Our Reference: SYD19/01350/12  
Departments Reference: SSD-10448

**RESPONSE TO SUBMISSIONS - ASPECTS INDUSTRIAL ESTATE – LOTS 54-58, DP259135 - MAMRE ROAD - KEMPS CREEK**

Reference is made to the Department's referral dated 9 March 2021 with regard to the abovementioned State Significant Development Application (SSDA), which was referred to Transport for NSW (TfNSW) Services for comments.

Project	ASPECT INDUSTRIAL ESTATE MAMRE ROAD, KEMPS CREEK EXTERNAL INTERSECTION
Title	ROADWORKS AND STORMWATER DRAINAGE PLAN SHEET 1

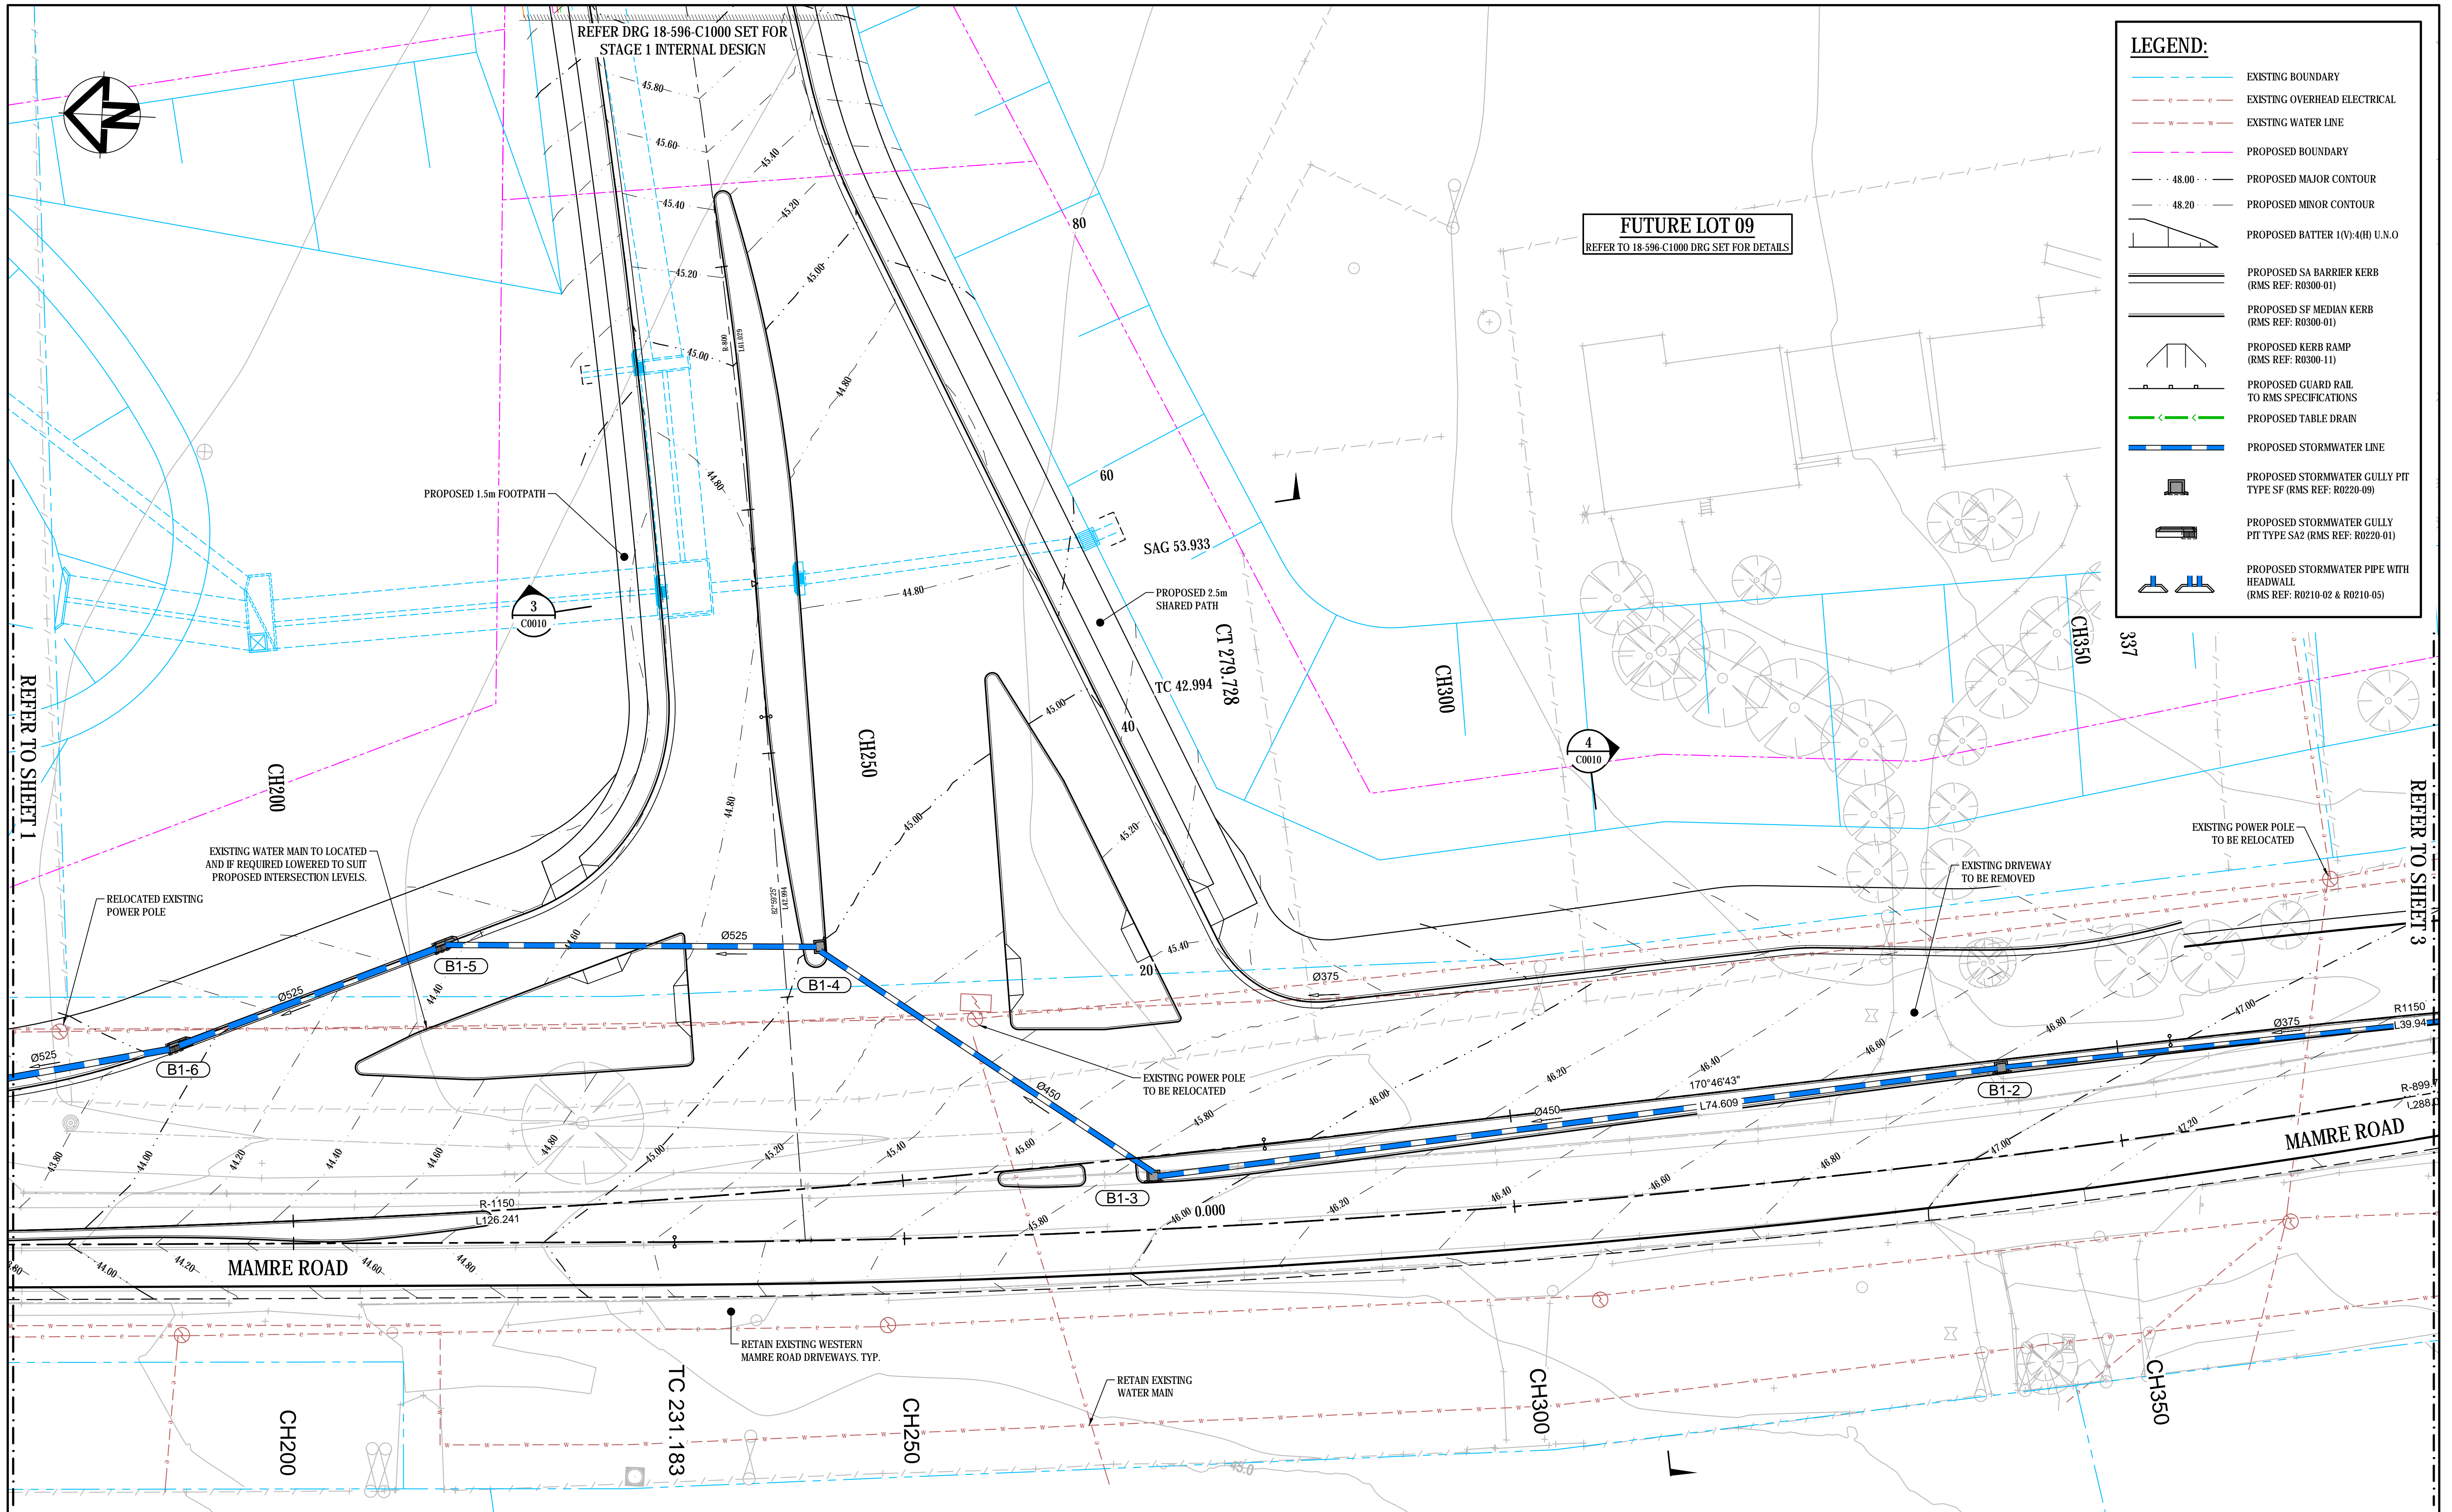
*TfNSW Item 3d* – TfNSW has concerns with the approach of the intersection design for the right turn on the northbound approach only accommodating for the expected yield under Stage 1 of this development. The reason TfNSW requests the traffic modelling to consider the cumulative traffic impact of the development in the context of any other known planning proposals and developments in the precinct and surrounds, is to determine the need for upgrades or improvement works including consideration to timing and funding (if required). The main concern is that when the other developments (inclusive of any staged approaches) come online this intersection will need to be adjusted again for another interim solution. This is not considered beneficial to the end user.

*TfNSW Item 3i* – TfNSW notes Asongroups comments which states that there is adequate capacity to accommodate the worst possible queue length for the northbound right turn movement which shows Level of Service (LoS) E/F. However referring to comment 3 of this letter should this design be considered, TfNSW is of the view that mitigation measures to improve the LoS of this movement should be considered.

It is recommended that the applicant coordinate with other known developments in the area to come up with the interim solution which could cater for all the developments using the intersection in the interim.

Consideration should be given to mitigation measures to improve the Level of Service of this movement.
